**Consultation Response from KC,
Highways Development Management**

2022/91966 adj, Sunny Mede, Woodhead Road, Holmfirth, HD9 2PX

Outline application for erection of residential development

title Site Plan as Proposed  
number 22010D-04-P01  
scale 1:100/1:200/1:500/1:1250  
size A1

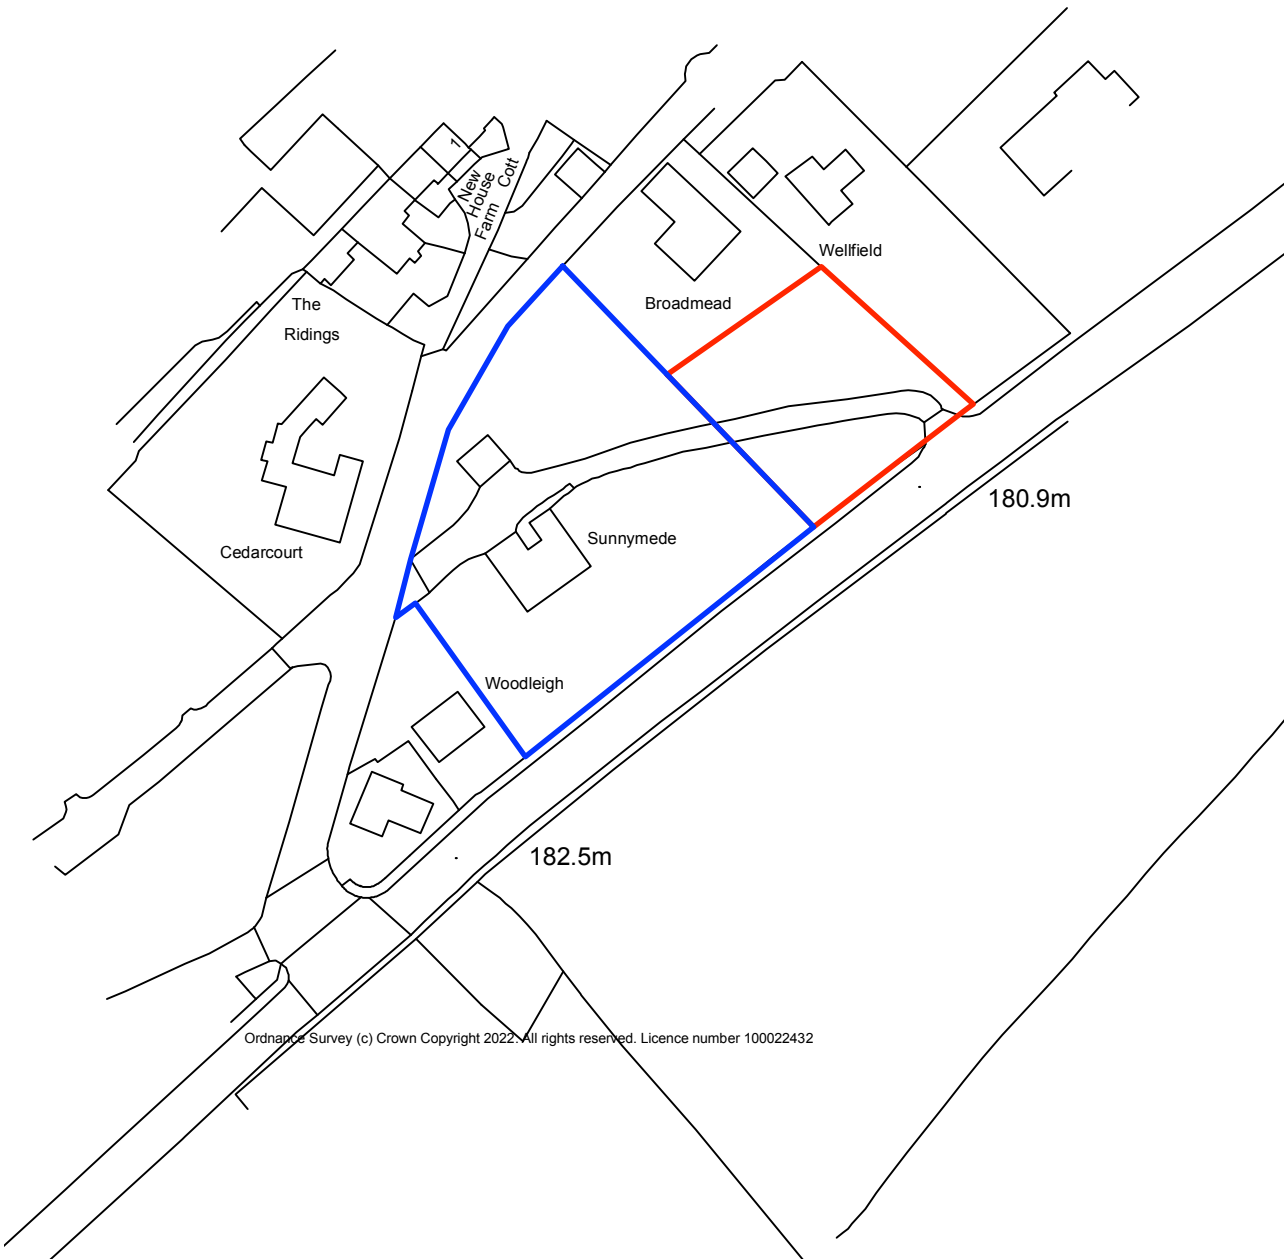
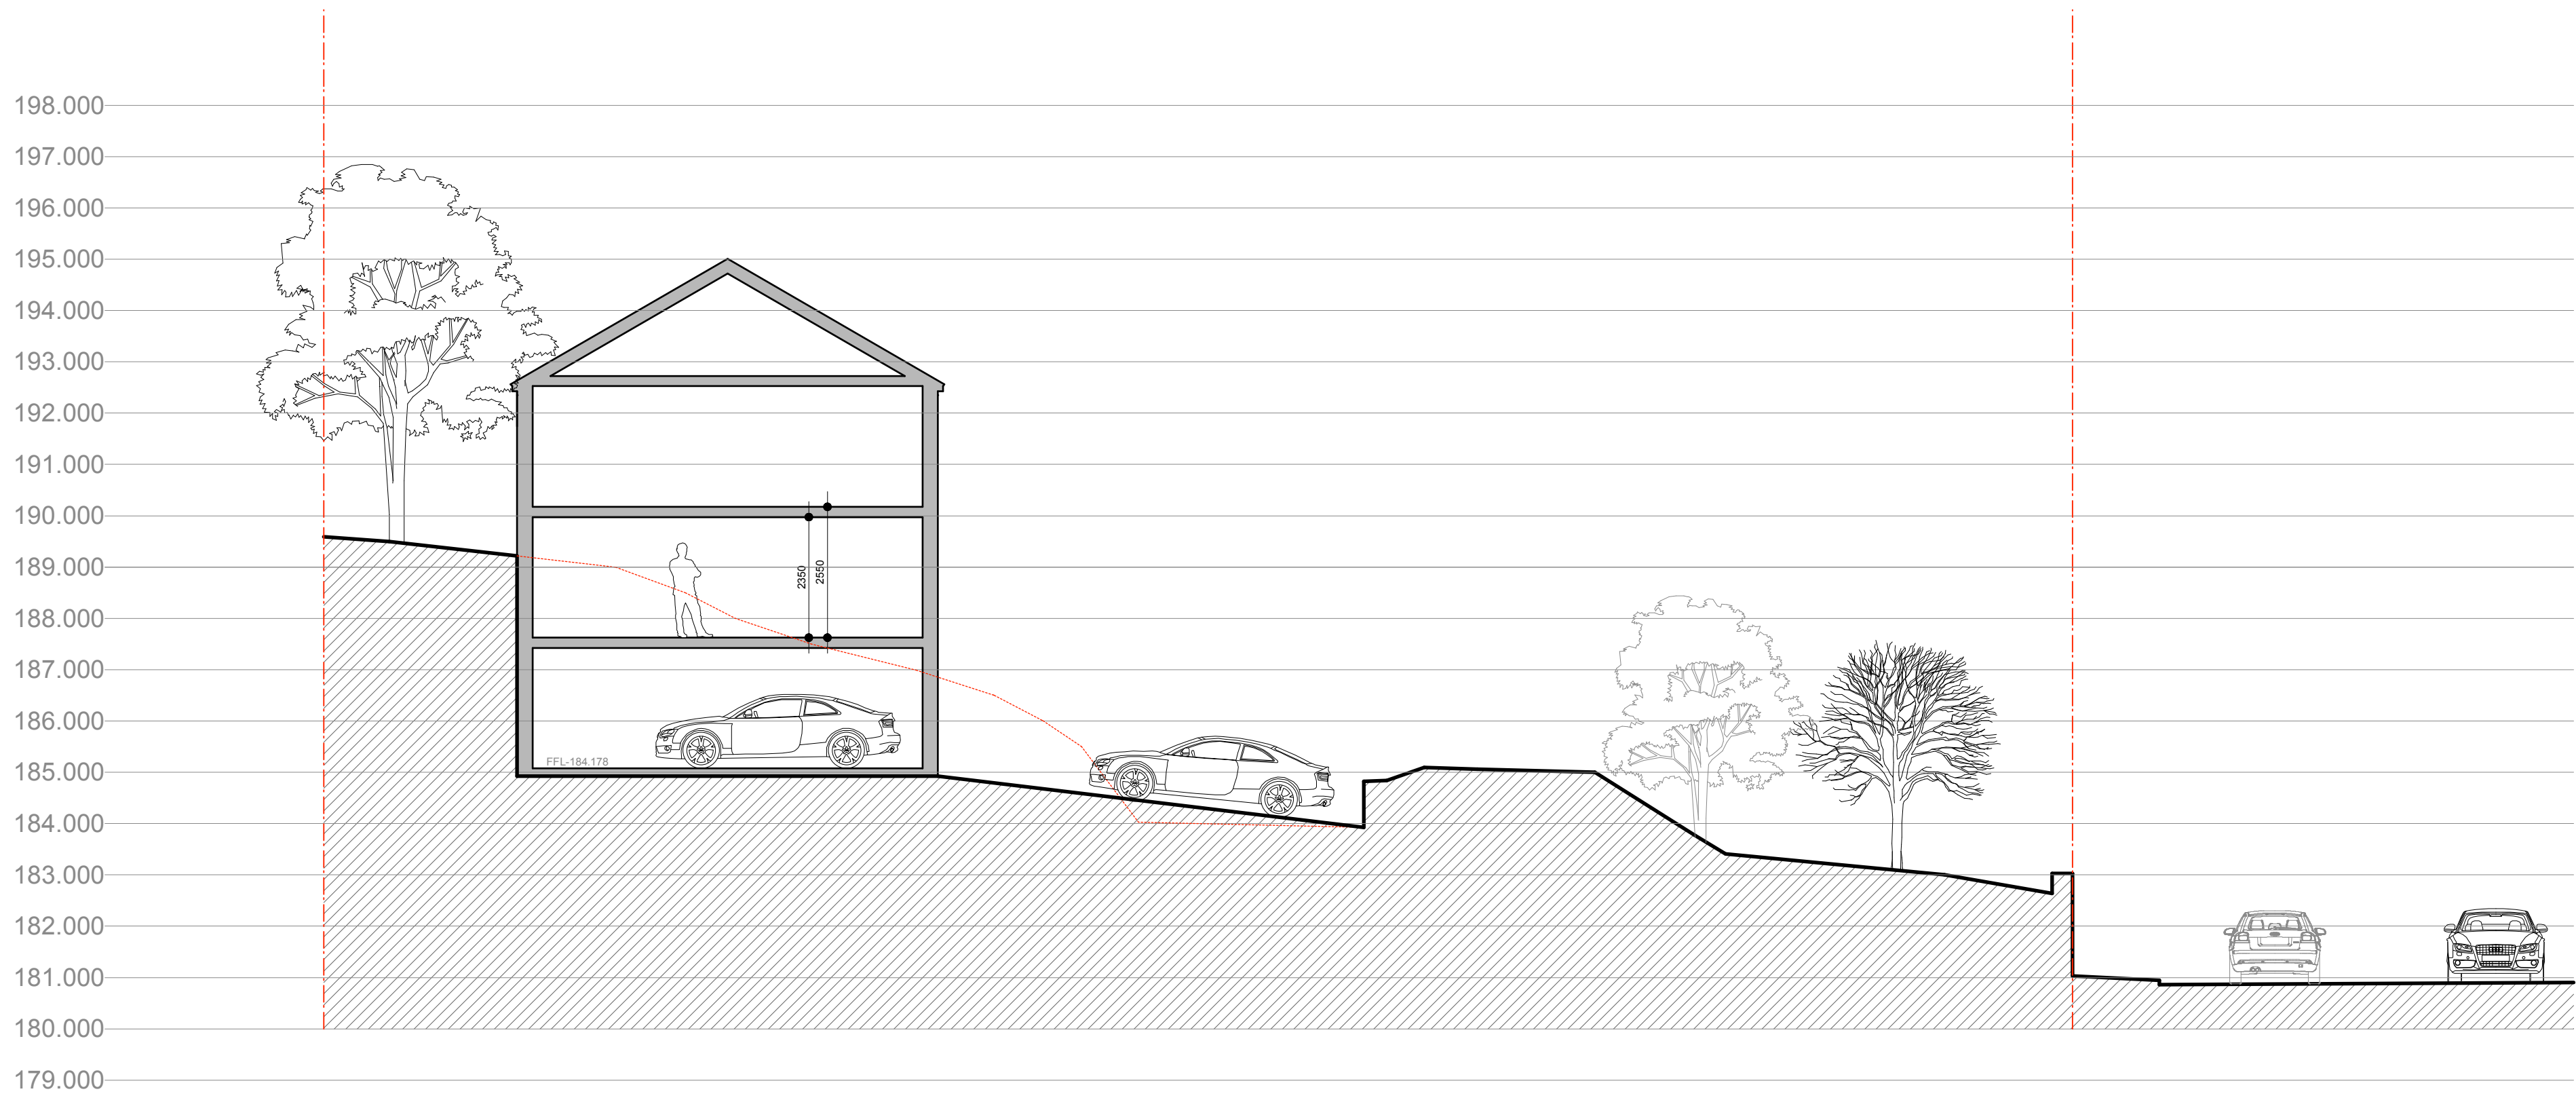
Drawing no. 22010D-04-P01 shows the proposed dwelling will be served by at least three off-street parking places with internal turning. The site uses the established access of Woodhead Road, with the host building taking access from Shaw Lane via another existing access point.

A reserved matters application should show bin storage and collection pads for each dwelling, but at this outline stage, Highways DM has no wish to raise objection to the scheme.

Prior to the development being brought into use, the approved vehicle parking areas shall be surfaced and drained in accordance with the Communities and Local Government; and Environment Agencies 'Guidance on the permeable surfacing of front gardens (parking areas)' published 13th May 2009 (ISBN 9781409804864) as amended or superseded; and thereafter retained throughout the lifetime of the development.
